Our Ref: A/50/19/HH
Your Ref:

Town & Country Planning Act 1990 (as amended)
Town & country Planning (Development Management Procedure) (England) Order 2015
Application for Planning Permission for Works or Extension to a Dwelling

Development The addition of an open glass canopy to the rear elevation of the property.
Location Old Pines 28 East Drive Angmering

Block Plan shows area bounded by: 506234.88, 103467.83 506324.88, 103557.83 (at a scale of 1:500), OSGridRef: TQ 627 351. The representation of a road, track or path is no evidence of a right of way. The representation of features as lines is no evidence of a property boundary.

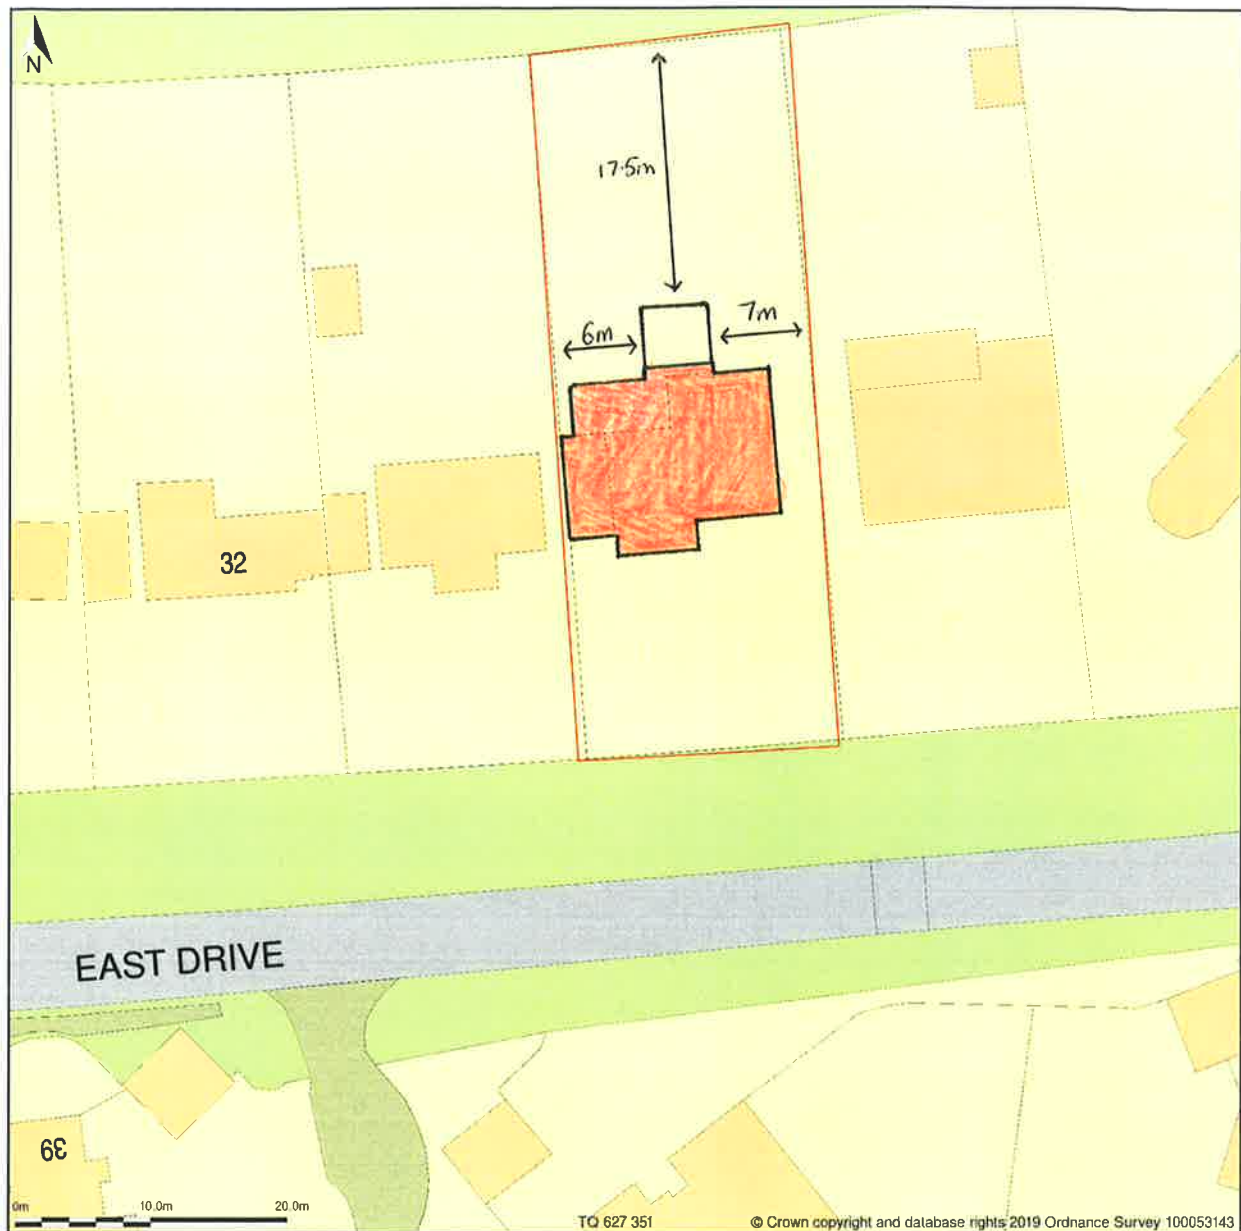
Block Plan

Please submit 1 electronic or 3 paper copies of a block/site plan which includes dimensions from the proposed canopy to the site boundaries.
